DOC18-327885-33

**Sutton Forest Quarry Project, Hume Highway, Sutton Forest (SSD 6334)**

I am writing in reply to your email to the Environment Protection Authority (EPA) dated 23 May 2018 seeking comments on the above development application and accompanying Environmental Impact Statement.

Figure 2.1
 INDICATIVE QUARRY AREA LAYOUT

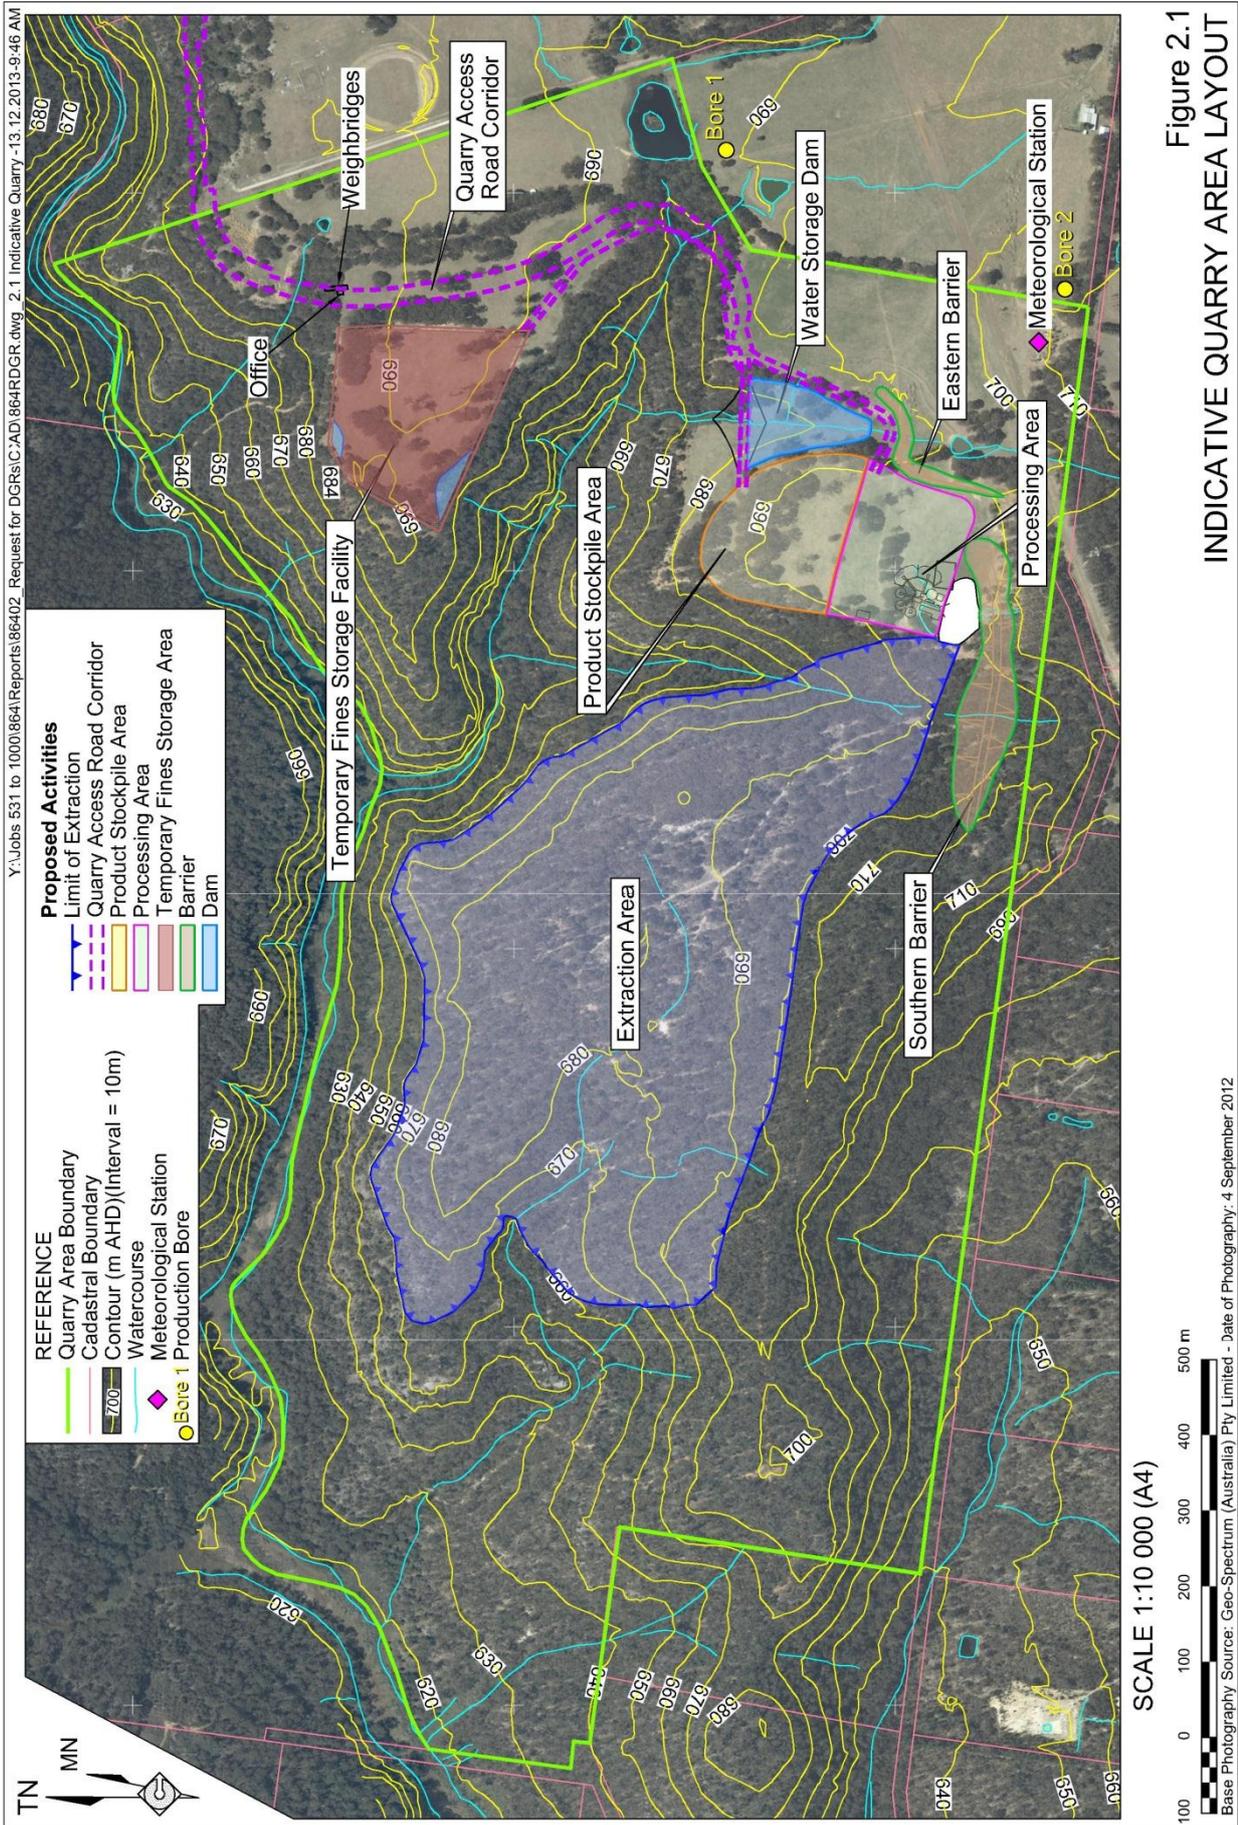
3. Section 2.3 and Figures 2.1 and 2.4 indicates that the "Fines Storage Area 2" and the "Temporary topsoil and mulch stockpile area" are located within the area allocated for Stage 6 and possibly part of the Stage 7 extraction area. The EIS states that the Fines Storage Area 2 is located within the area to be developed in Stage 4. According to Figures 2.1 and 2.4, the Fines Storage Area 2 is located within the proposed area for Stage 6.

The EIS also states that the temporary topsoil and mulch stockpile area is located within the area to be developed in Stage 6 to avoid the need to stockpile soil or mulch in an area requiring clearing of native vegetation. As stated in Section 2.1.2 of the EIS, Stages 6 and 7 will be the subject of a separate development application. According to a Google Maps image, Stages 6 and 7 are in areas which would require removal of vegetation for the storage of topsoil and mulch. Should development consent be granted for the proposed project, activities undertaken within Stages 6 and 7 would not appear to be covered by the consent and these areas should not be impacted by the proposed development. The EPA requests that additional information is provided to clarify this matter.
